Engineers Comments Regarding Surface Water Drainage

Condition 8:

APPLICATION NO: BR/57/20/DOC

Site Address: 15-17 Kew Gardens Bognor Regis PO21 5RD

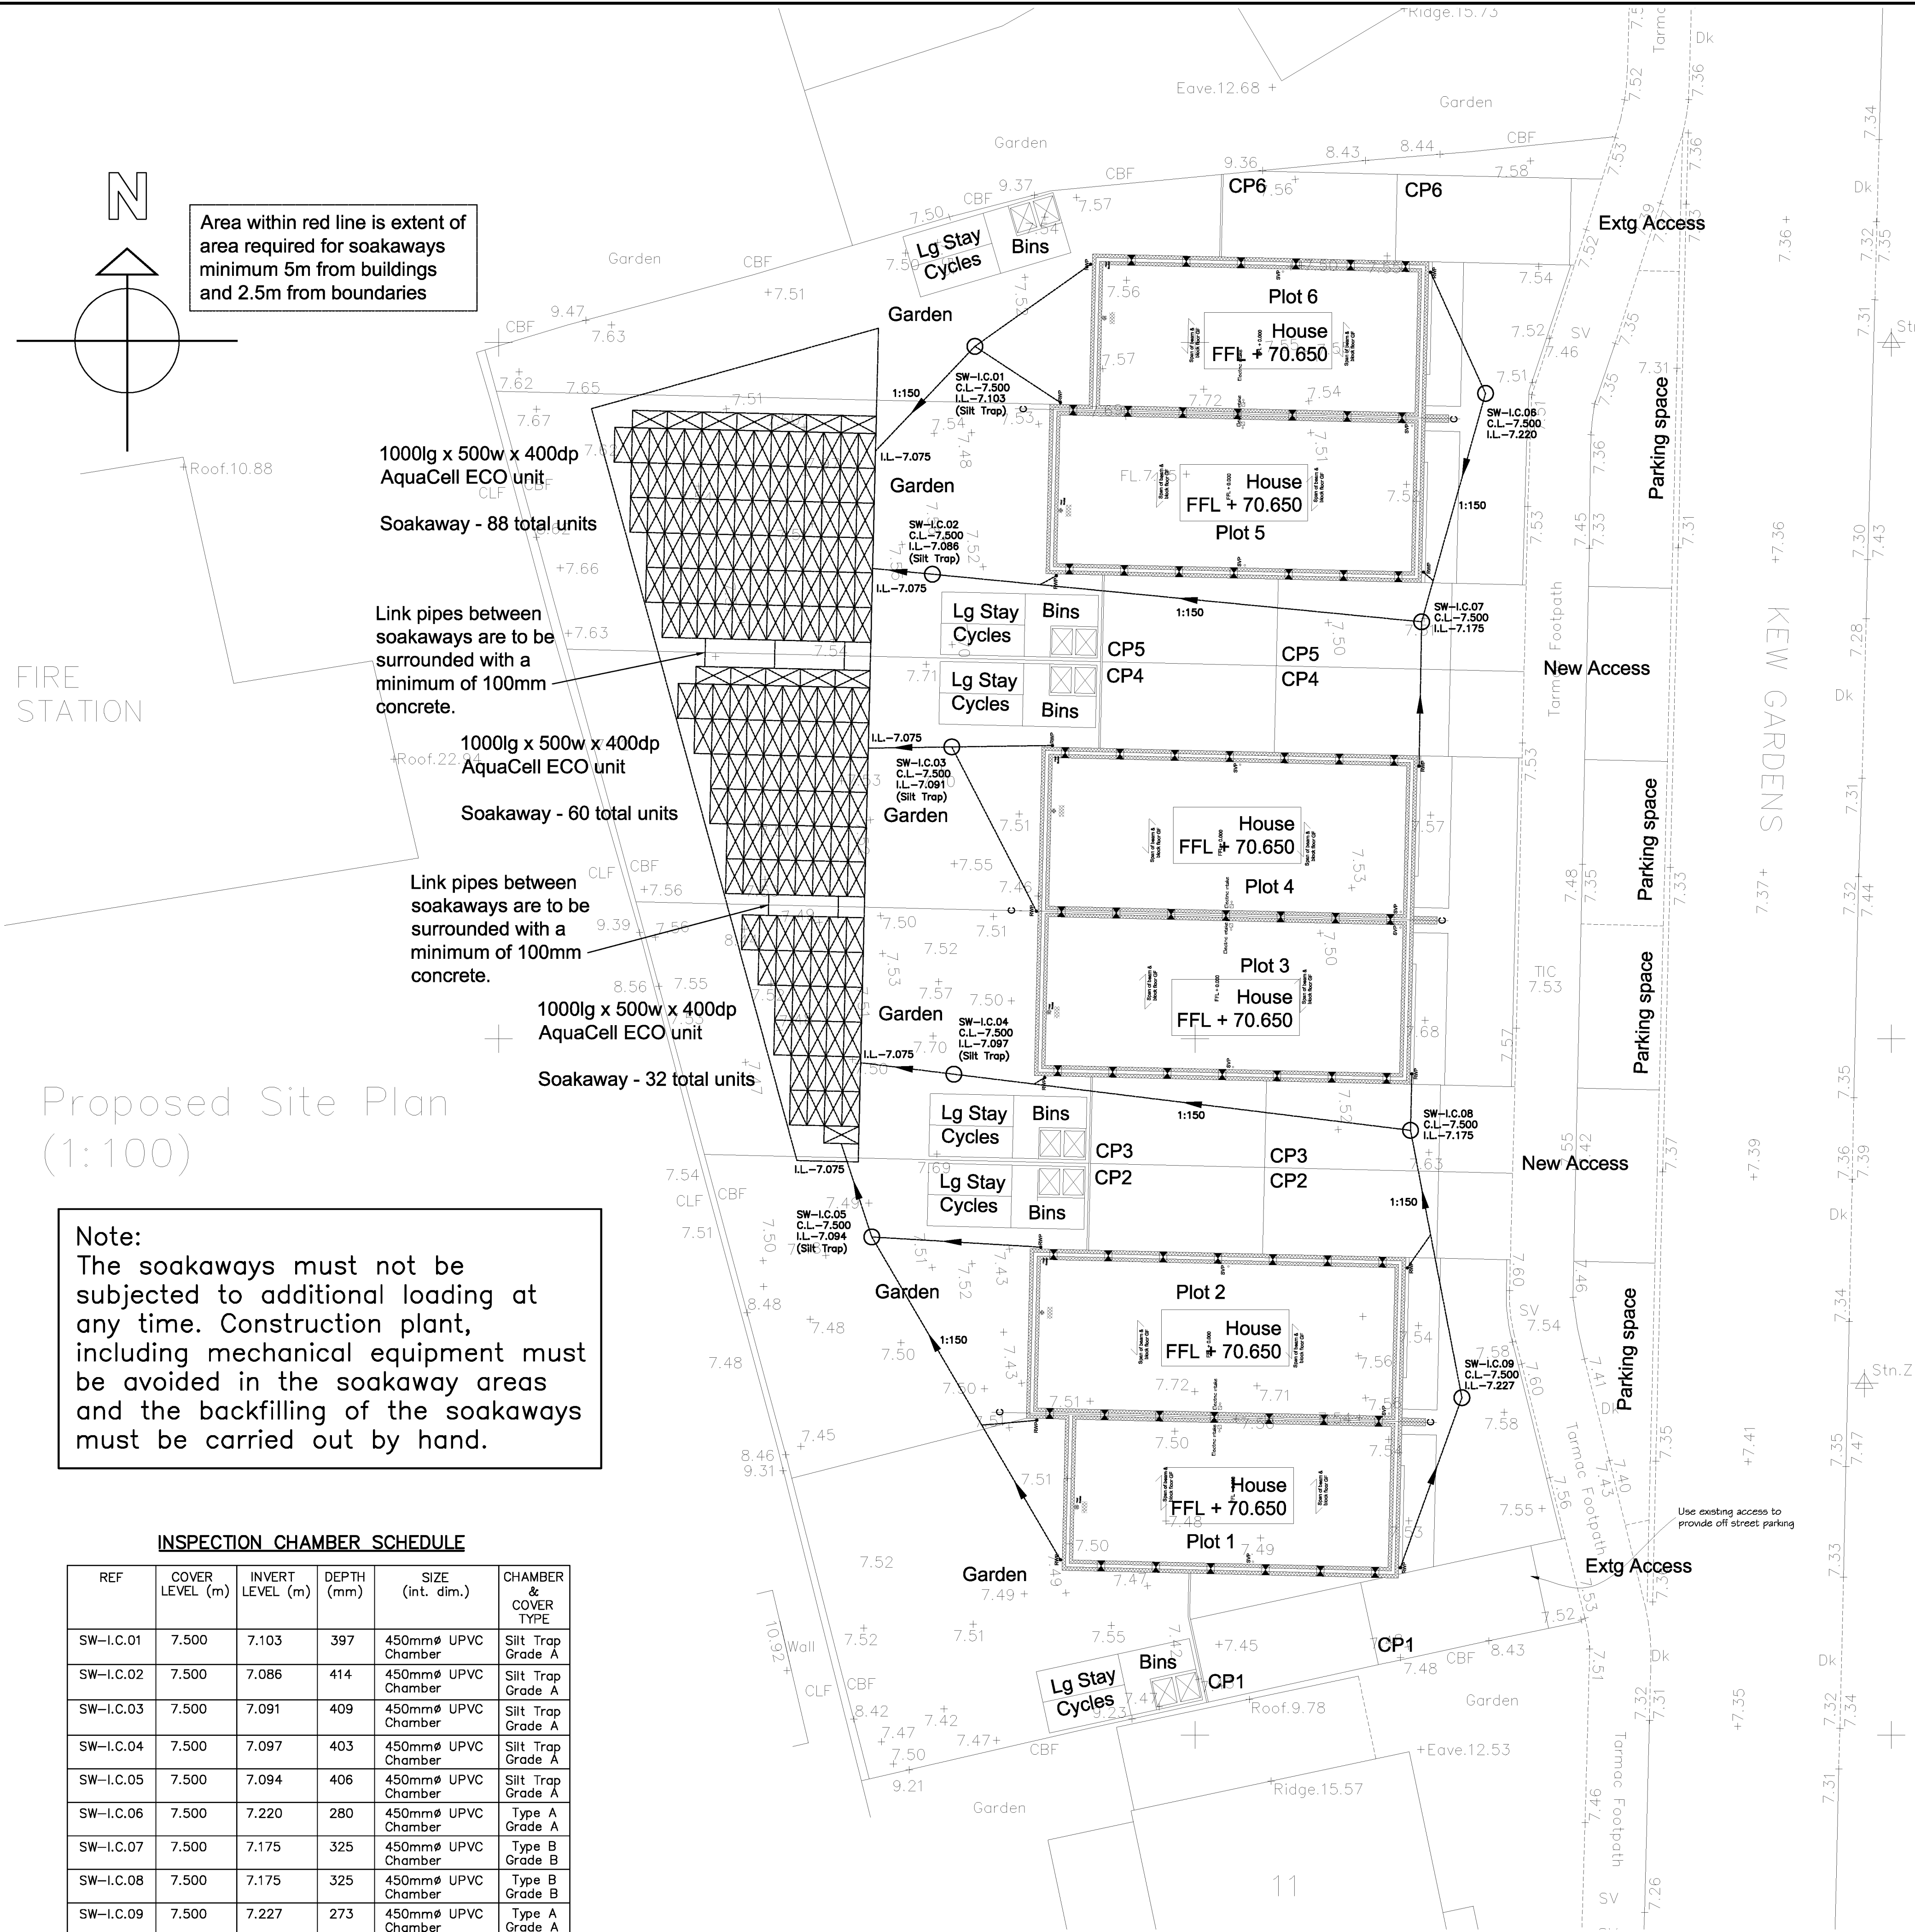
1. Soakaway crates are shown going beneath the boundary fences at plot 2/3 and plot 5/6. The design needs to be modified so that no crates are under boundary fences. *Done.*
2. The link pipes between the soakaways need to be surrounded in concrete and it is strongly advised that the applicant includes an inspection chamber on at least one of these pipes (please label this manhole/inspection chamber with invert and cover levels and cover type). *Concrete surround specified, no inspection chamber.*
3. Please label all pipes with the diameters, pipe materials, surround type, falls and/or invert levels. (If the diameters and materials are consistent a note to that effect stating the specification is sufficient). *Done.*

1. Soakaway crates are shown going beneath the boundary fences at plot 2/3 and plot 5/6. The design needs to be modified so that no crates are under boundary fences.
2. The link pipes between the soakaways need to be surrounded in concrete and it is strongly advised that the applicant includes an inspection chamber on at least one of these pipes (please label this manhole/inspection chamber with invert and cover levels and cover type).

TYPICAL SECTION
STORM WATER SOAKAWAY DETAIL
1:20

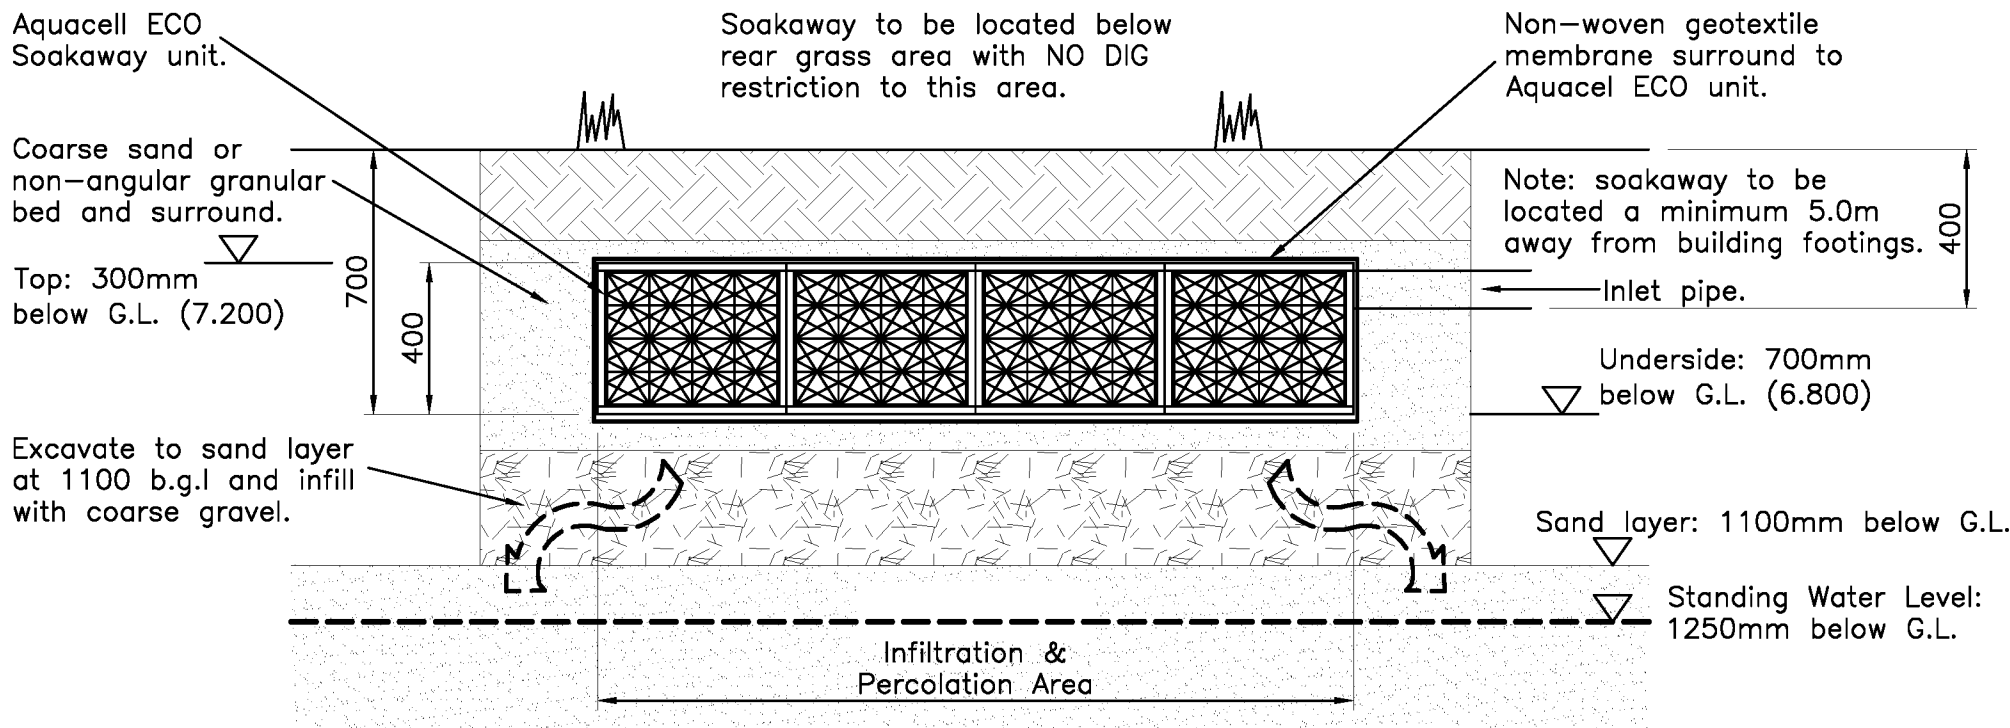
4. Please label soakaways with their invert levels, cover levels and cover types (not necessary if construction detail is kept on same drawing, in which case “see detail for levels” – only if moved to a separate construction details sheet, see below). This is still unclear, the existing topography shows ground level to be at 7.5 for most of the soakaway areas which will only provide 300mm of cover rather than the 400mm specified. Luckily this is acceptable with the chosen crates, however the note needs to be changed to reflect this. In addition, the levels on the site vary and yet the cover depth is uniform on the detail. It is assumed that the three soakaways will be set at the same base level 6.8. If this is the case, using the detail is sufficient, however the cover depth should be changed to reflect that it varies for the different soakaways. IE. Min 300mm and Min 700mm to the base of the soakaway.

4. Please label soakaways with their invert levels, cover levels and cover types (not necessary if construction detail is kept on same drawing, in which case "see detail for levels" – only if moved to a separate construction details sheet, see below).

450mm dia INSPECTION CHAMBER
NON-LOAD BEARING INSTALLATION (TYPE A)

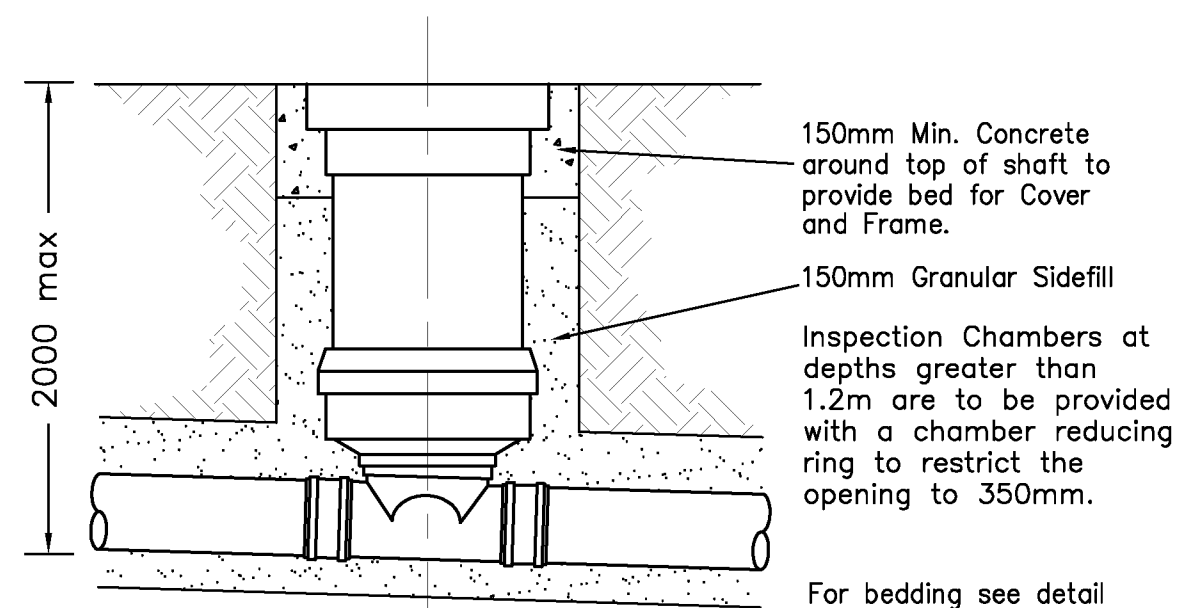
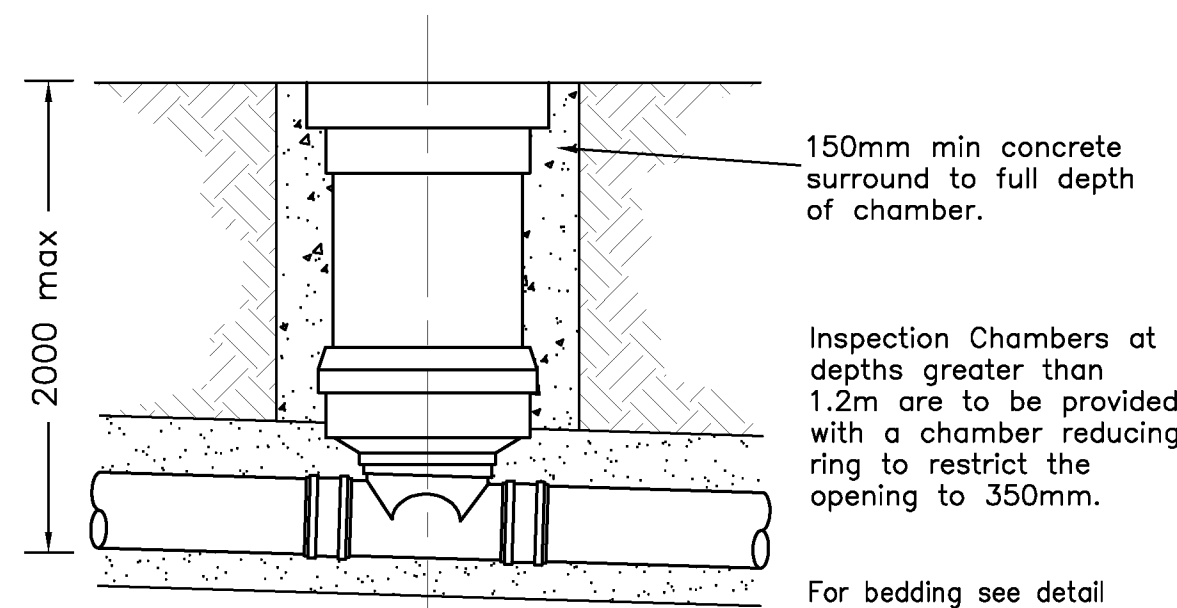
5. All silt traps need to be labelled with their invert levels.
6. Provide construction detail drawings for the silt traps, inspection chamber, permeable paving and the two different pipe bed and surrounds.

TYPICAL DETAIL FOR SILT TRAP
NON-LOAD BEARING AREAS

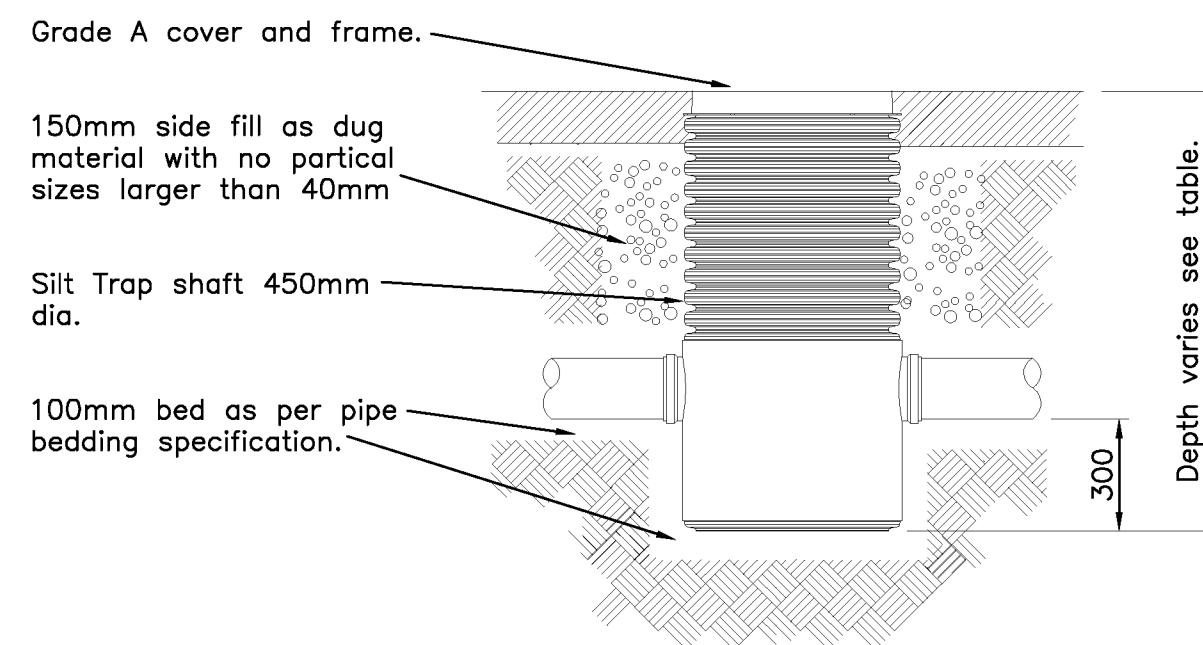
5. All silt traps need to be labelled with their invert levels. Done
6. Provide construction detail drawings for the silt traps, inspection chamber, permeable paving and the two different pipe bed and surrounds. Done.
